Response to Planning Application 21/00922/OUT

Housing at land west of Foxden Way, Great Bourton.

### Location Plan

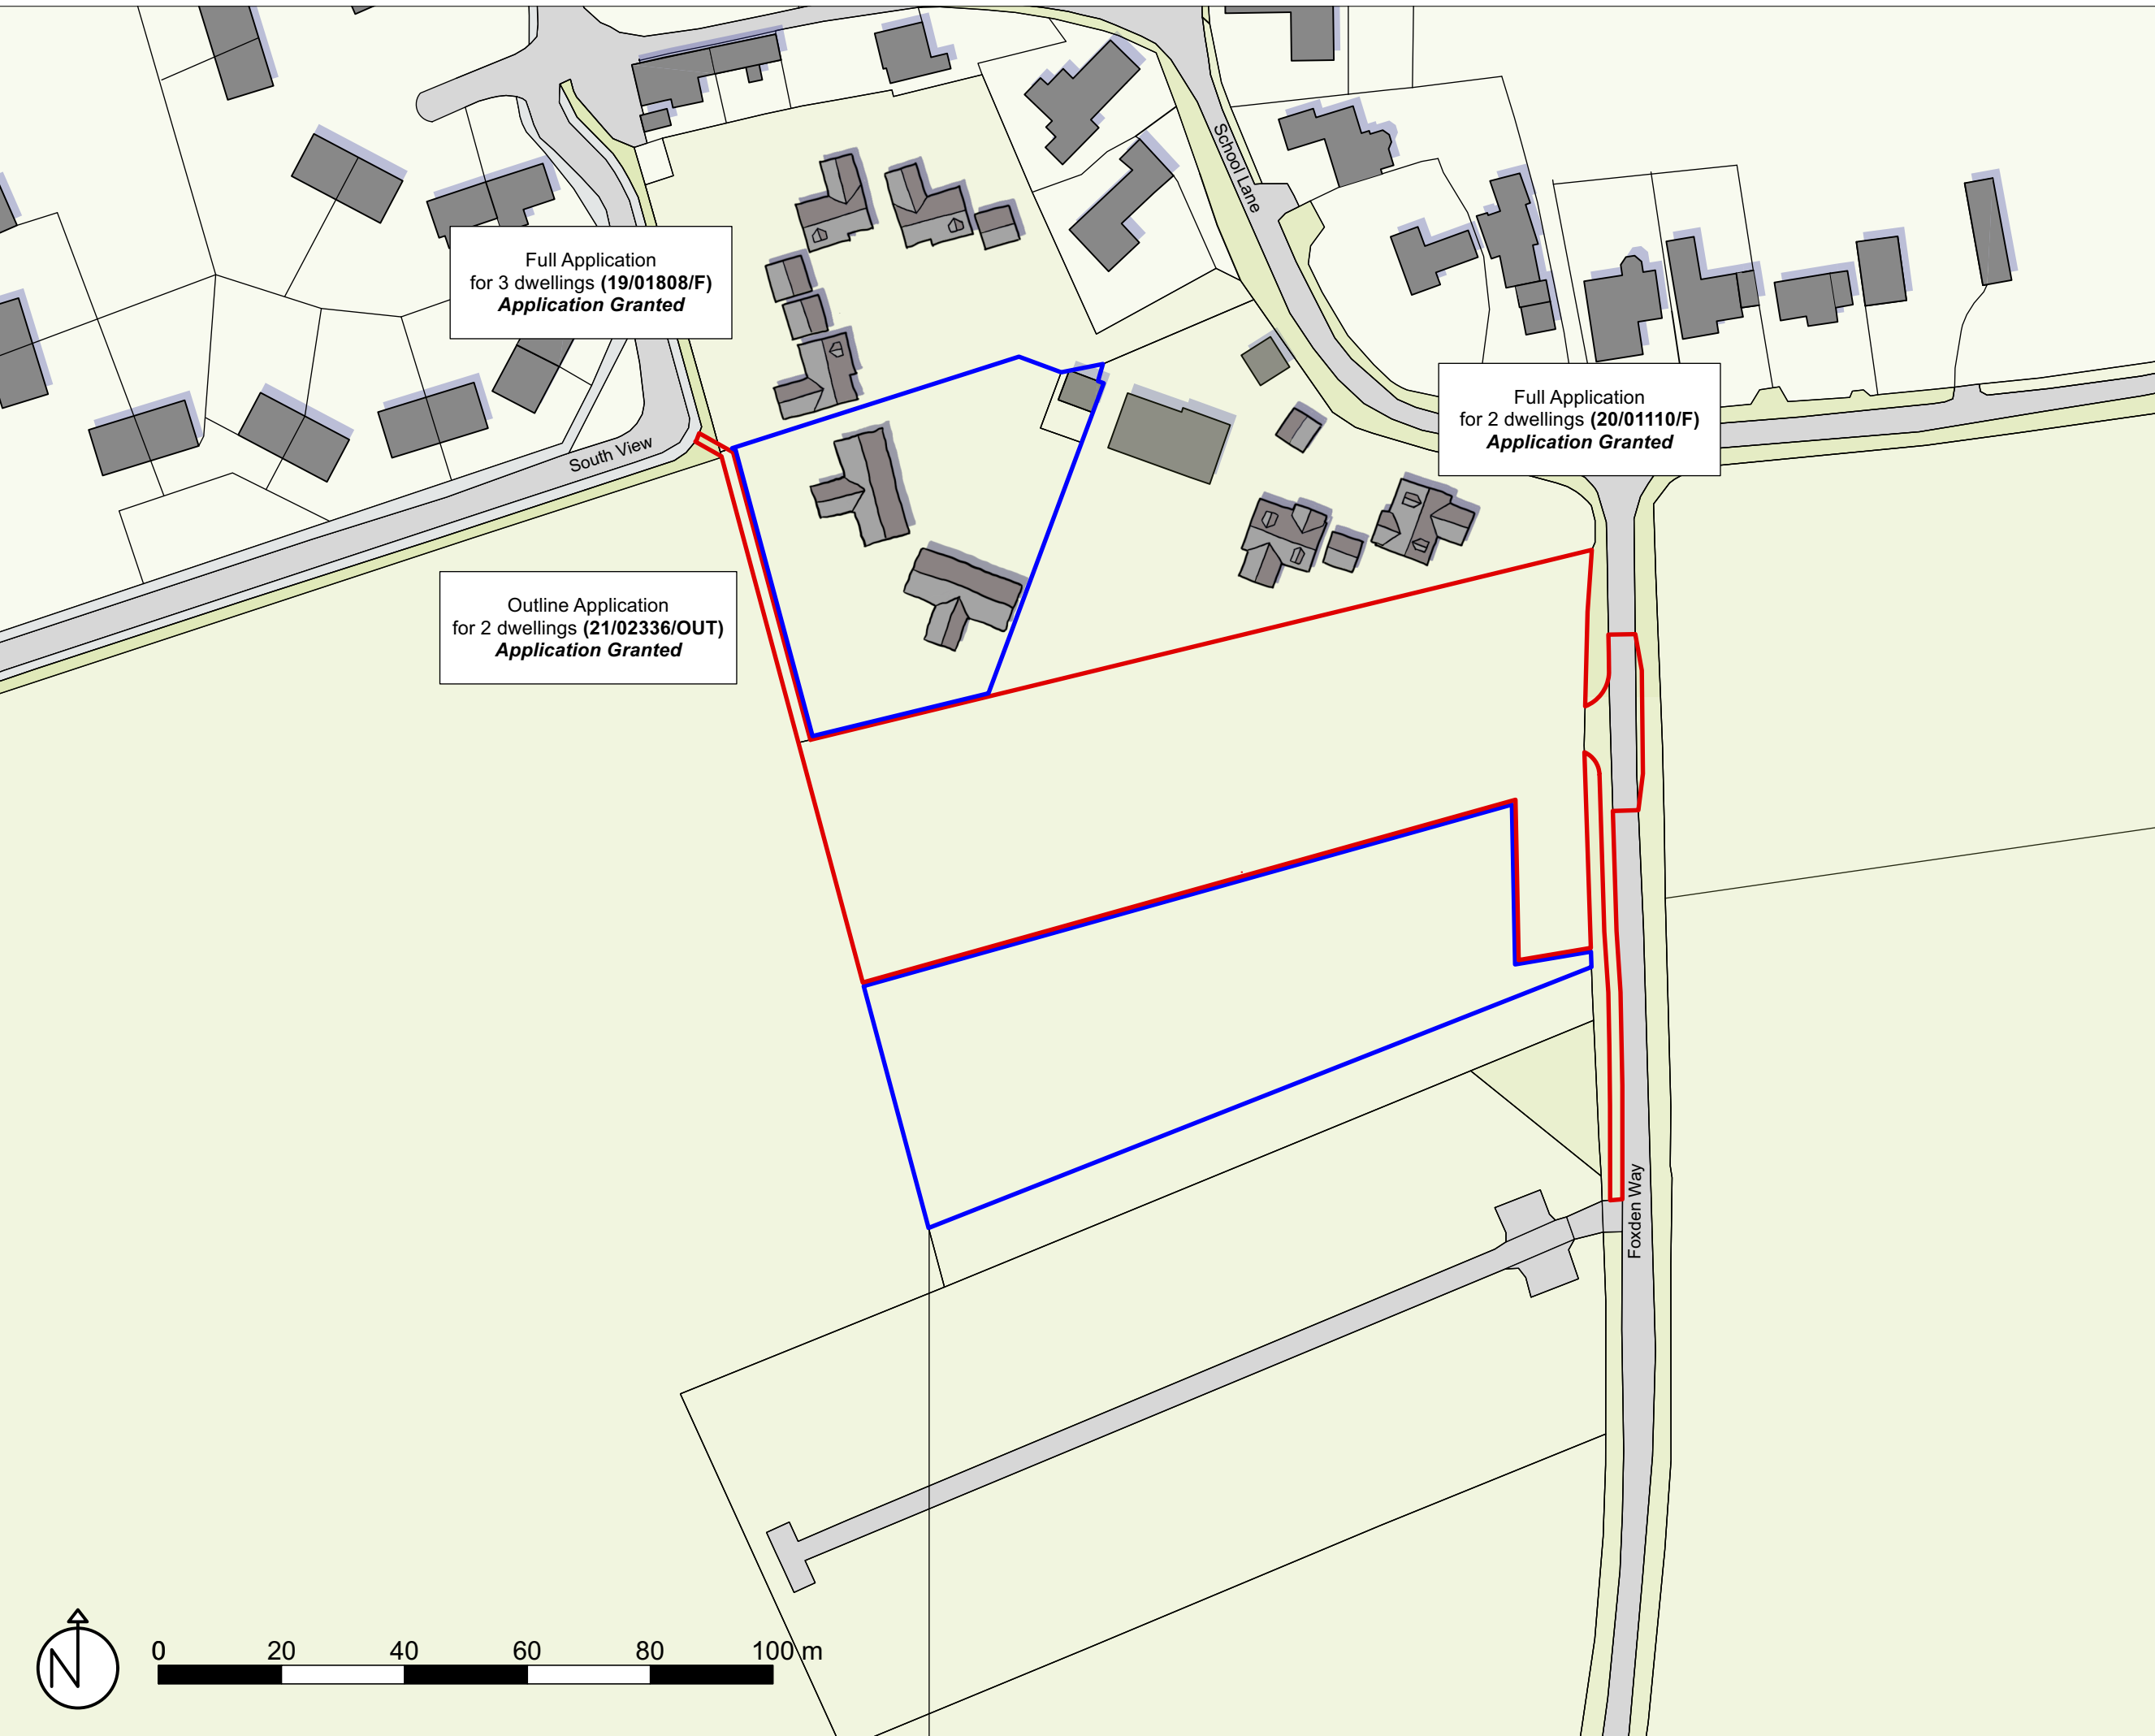
Incidentally, whilst considering the illustrative Masterplan, the suggested footpath through the site, linking from South View; who would have long term responsibility for the upkeep and maintenance of this, in perpetuity? Although proposed as an asset to allotment holders, giving on-foot access away from roads, I suspect that few tenants would view it as anything other than an additional threat to the security of their plots, crops, sheds and tools.

TITLE
PROPOSED SITE ACCESS JUNCTION WITH VISIBILITY SPLAYS

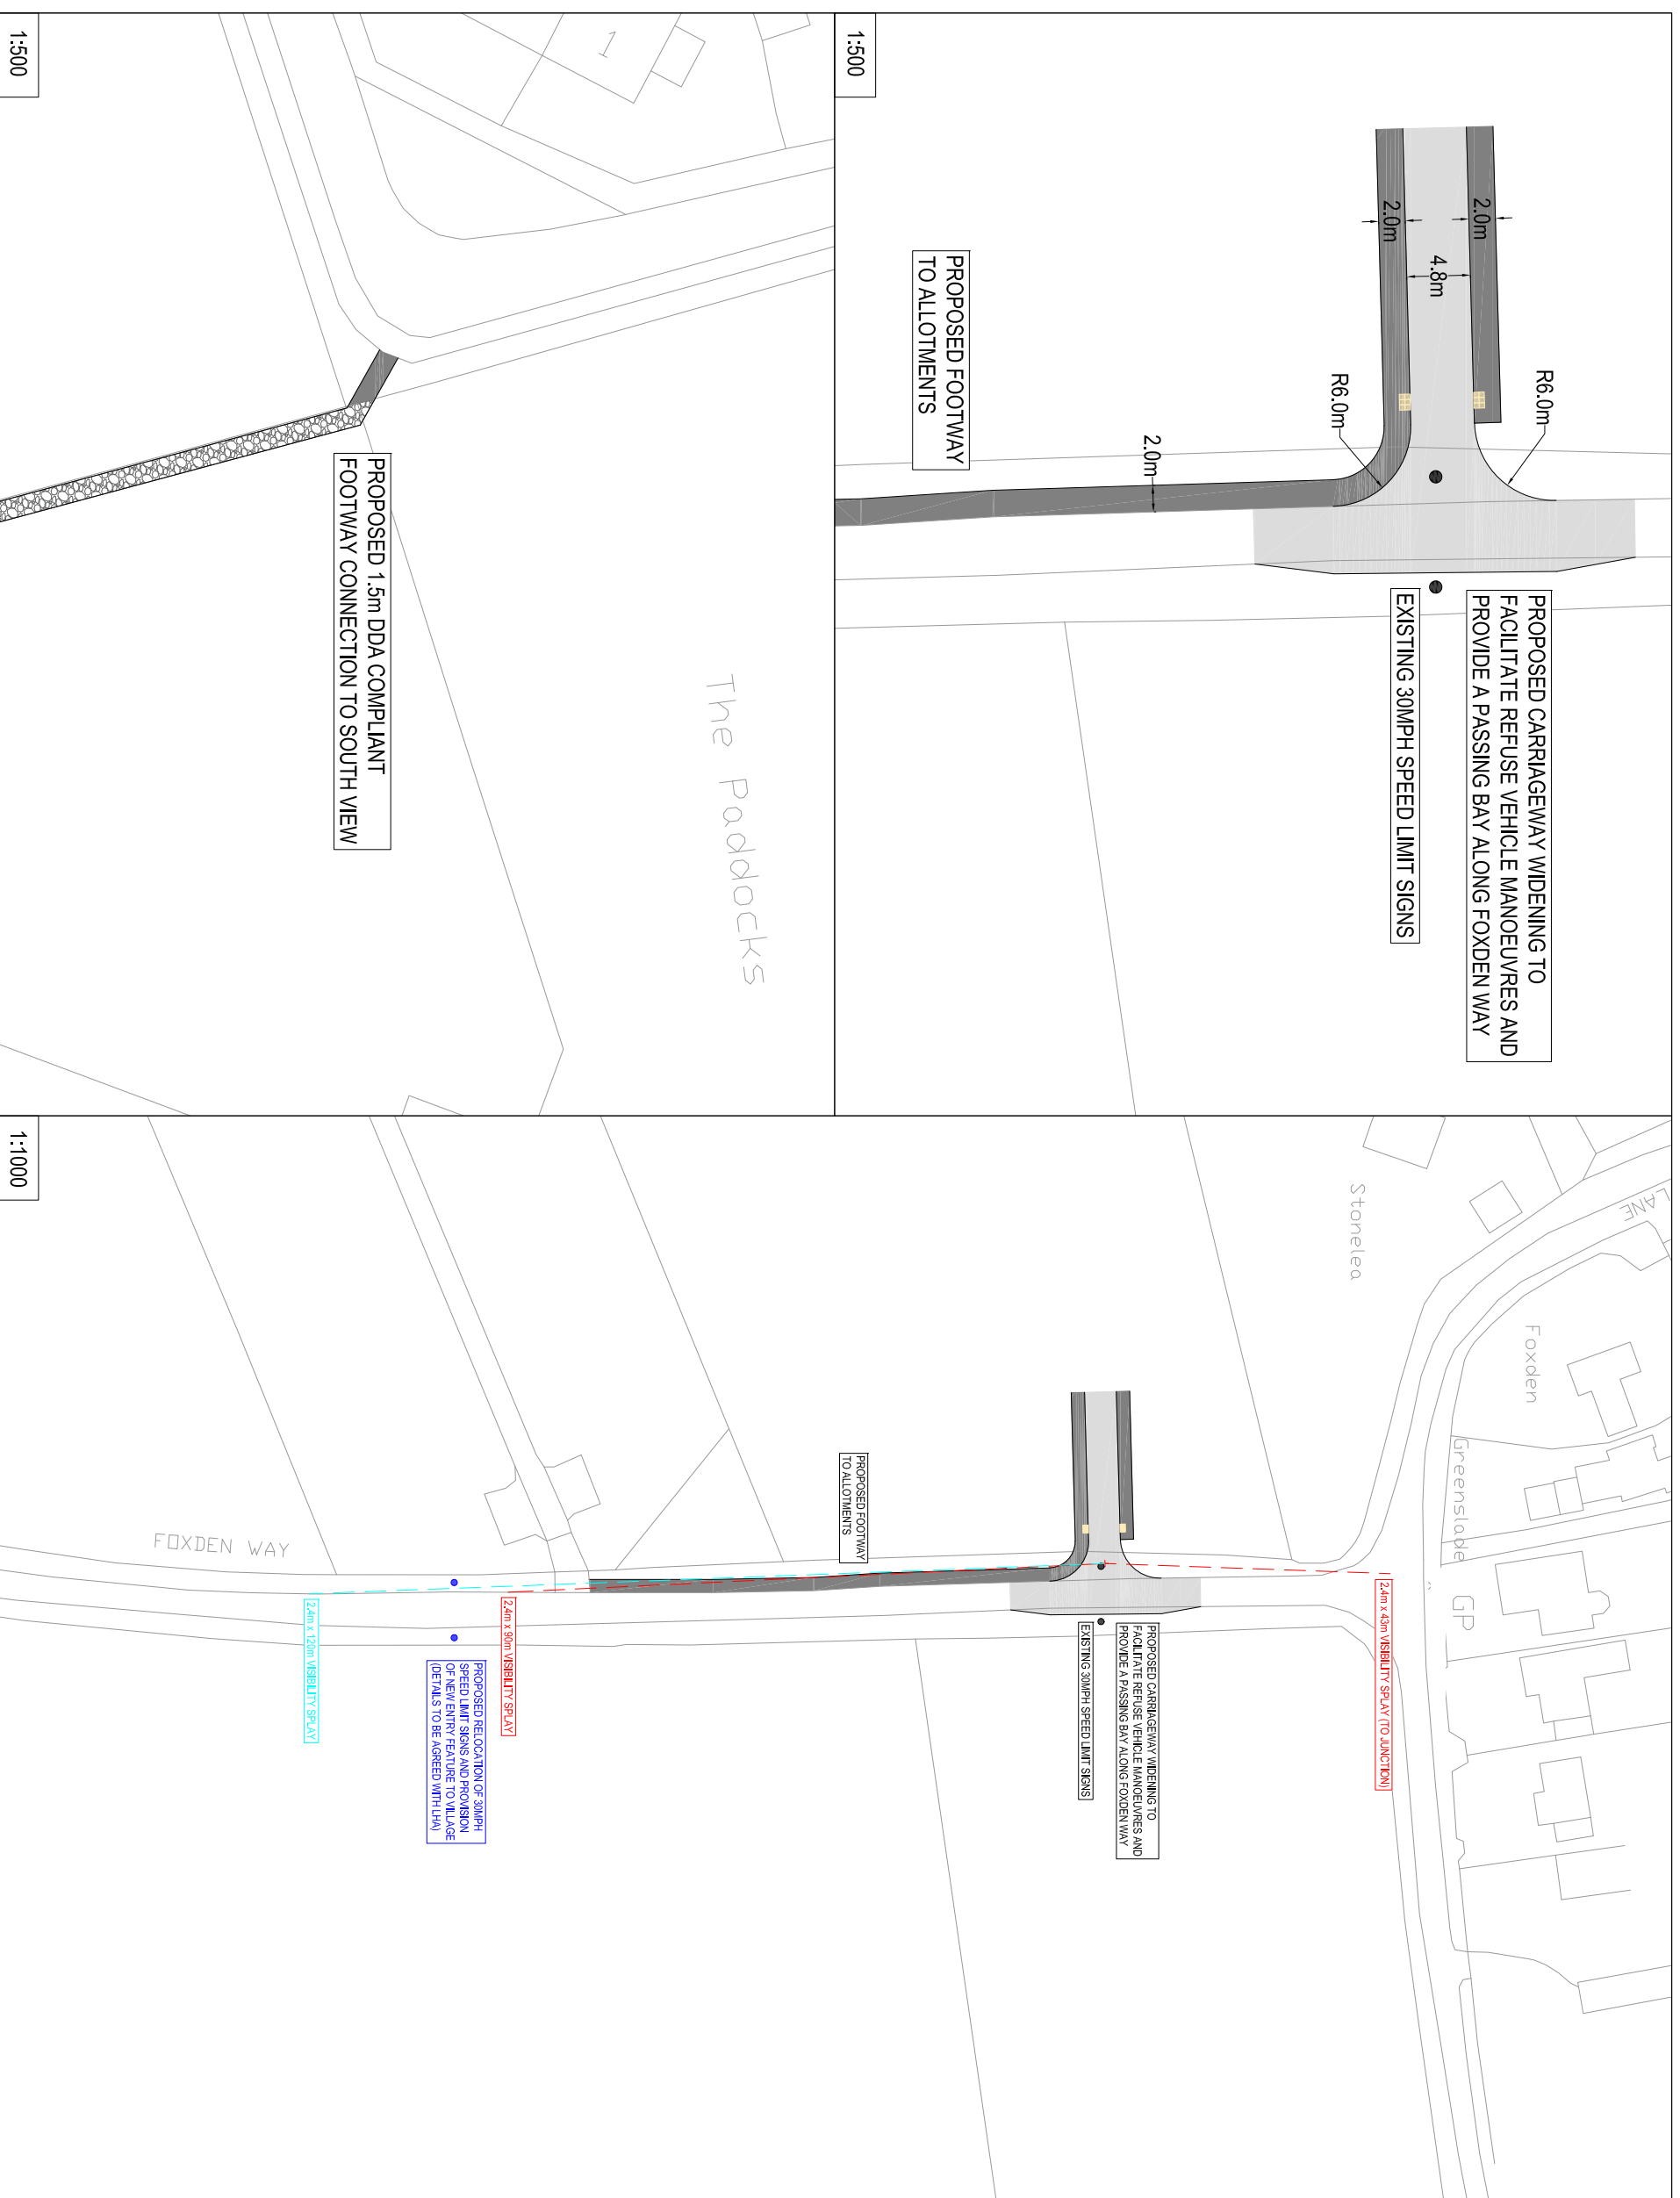
This correctly states 2.3 that 'Foxden Way is a rural lane of varying width generally 4'5m in the vicinity of the site' understating that in many parts the road surface is considerably narrower than this, and has only been 'informally' widened by passing vehicles having to go off the edge of the road, additionally breaking away the edges of the tarmac. At 2.7 it is stated that 'these are lightly-trafficked rural lanes that essentially operate as 'quiet lanes', being safe for pedestrian use alongside vehicular traffic'. During 2020 lockdown, when schools were closed, many businesses closed, many people working from home or furloughed there has been a lessening of traffic, and as has been described by many objectors, this relatively level road has been heavily used for exercise, by residents of Great and Little Bourton, and from further afield, especially from the estates on the Southam Road. It is regularly part of the route of The Banbury Run, and a district cycle race and participants come and practice. However, traffic is now building again. We own a piece of land next to Foxden Way and when working there we are very conscious of just how many vehicle use the road. The traffic flow survey from 2019 cited at 2.8 in the Hub report was only set to monitor movements on School Lane and so was not representative of all traffic using Foxden Way and that used Crow Lane, which takes traffic from the Cropredy direction as well as Gt Bourton, and the roads in Little Bourton.

The Transport Note surmised that cars would be driven to and from the proposed site via School Lane, Great Bourton. It seem much more likely that would only be if you were heading north on the A423, or Cropredy direction via Crow Lane. Anyone heading towards Banbury and beyond to the South, to the M40 Junction 11, or to the west, is much more likely to drive in the direction of their final destination and turn right onto Foxden Way ,heading for Little Bourton and its narrow roads and tight bends on Spring Lane, and then Chapel Lane, and its difficult junction with the A423, Southam Road.

Surface water drainage: It is proposed that rainwater would be drained on site through the various permeable surfaces into a water collecting feature in the southwestern corner of the site and thence gradually carried away by the existing roadside ditch system. This ditch is poorly maintained and not continuous as far as Mill Lane. Perhaps where the western ditch stops it is supposed to be piped under the road to the ditch on the eastern side of the road.

Whether that pipework is still extant after attack by all those heavy vehicles along the lane I do not know. What I do know is that after heavy rain water from the land on the west floods across the road creating a hazard, which is even worse when that water freezes into black ice
